To Protect and Promote the Health and the Environment of the People of Kittitas County

Date: January 21, 2025

Subject: Short Plat Application SP-25-00002 Sageview

SAGEVIEW BLA/SHORT PLAT

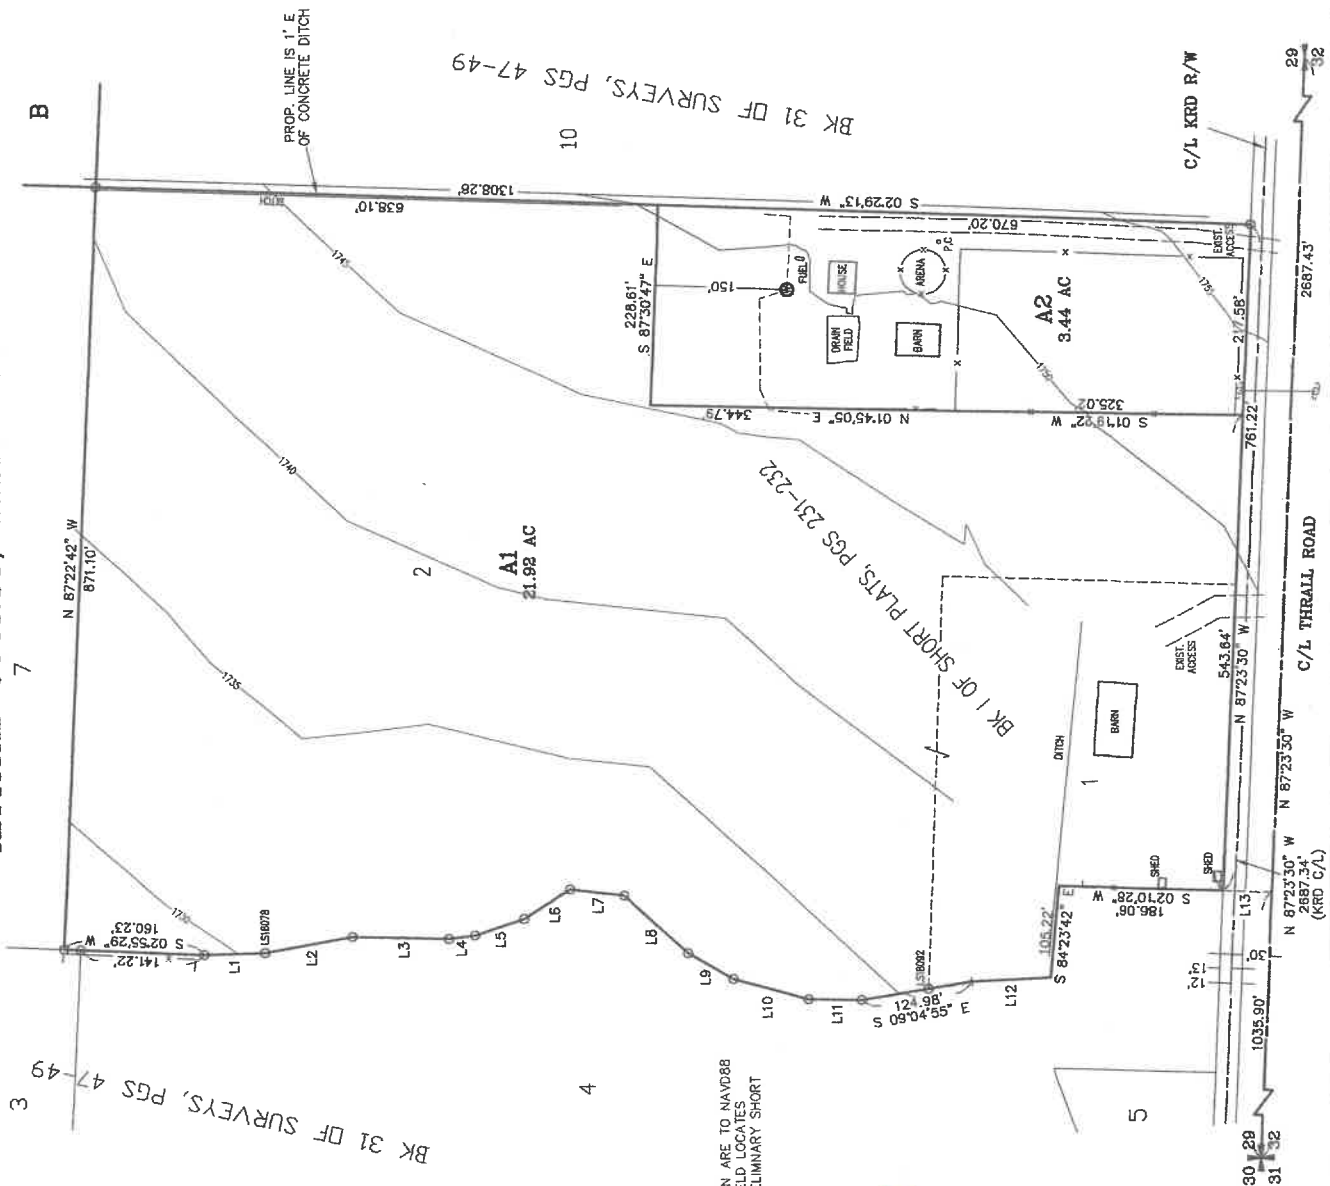
- The existing individual well on proposed lot A2 does not appear to meet the required 50-foot property line setback. If the existing well does not meet this setback requirement, the applicant may request an exemption from the current regulations.

- Soil logs must be performed and recorded for each new lot within the proposed short plat.
